Consultee Comments for Planning Application 17780/24

Application Number: 17780/24

Address: 14 Glebe Street Westhoughton Bolton BL5 3SZ

Proposal: ERECTION OF A TWO STOREY SIDE EXTENSION.

Block Plan 1:200 @ A4

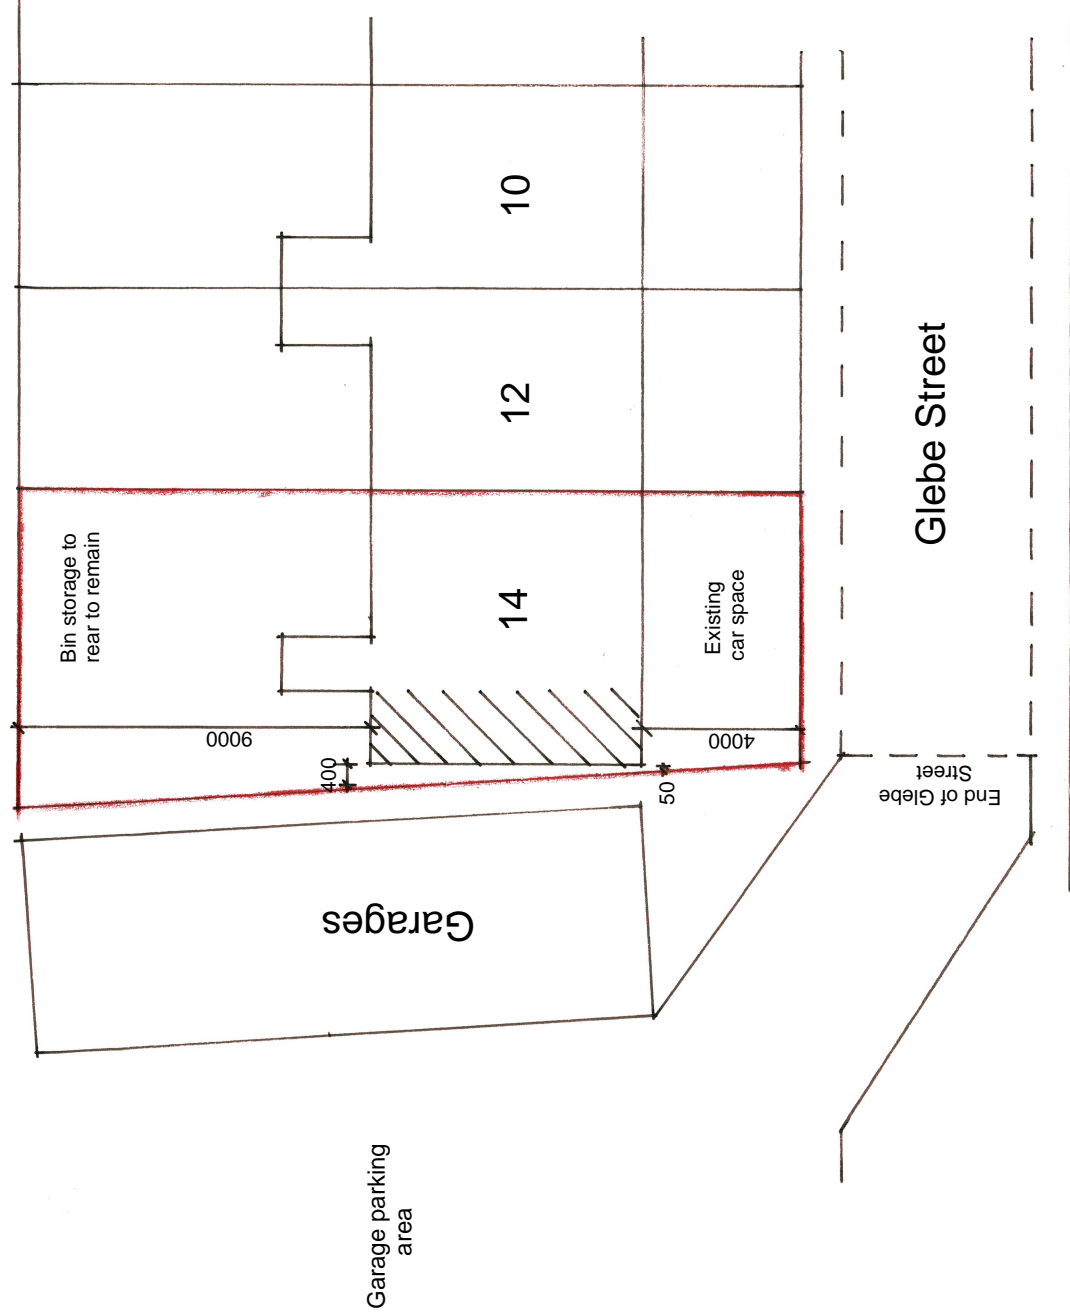
No reasonable objections on highway grounds to what is being proposed under this application subject to the Councils residential parking standards being met in full to serve the increase in the number of habitable rooms associated with the property.

HS05-3 spaces (2.4m x 4.8m each space).
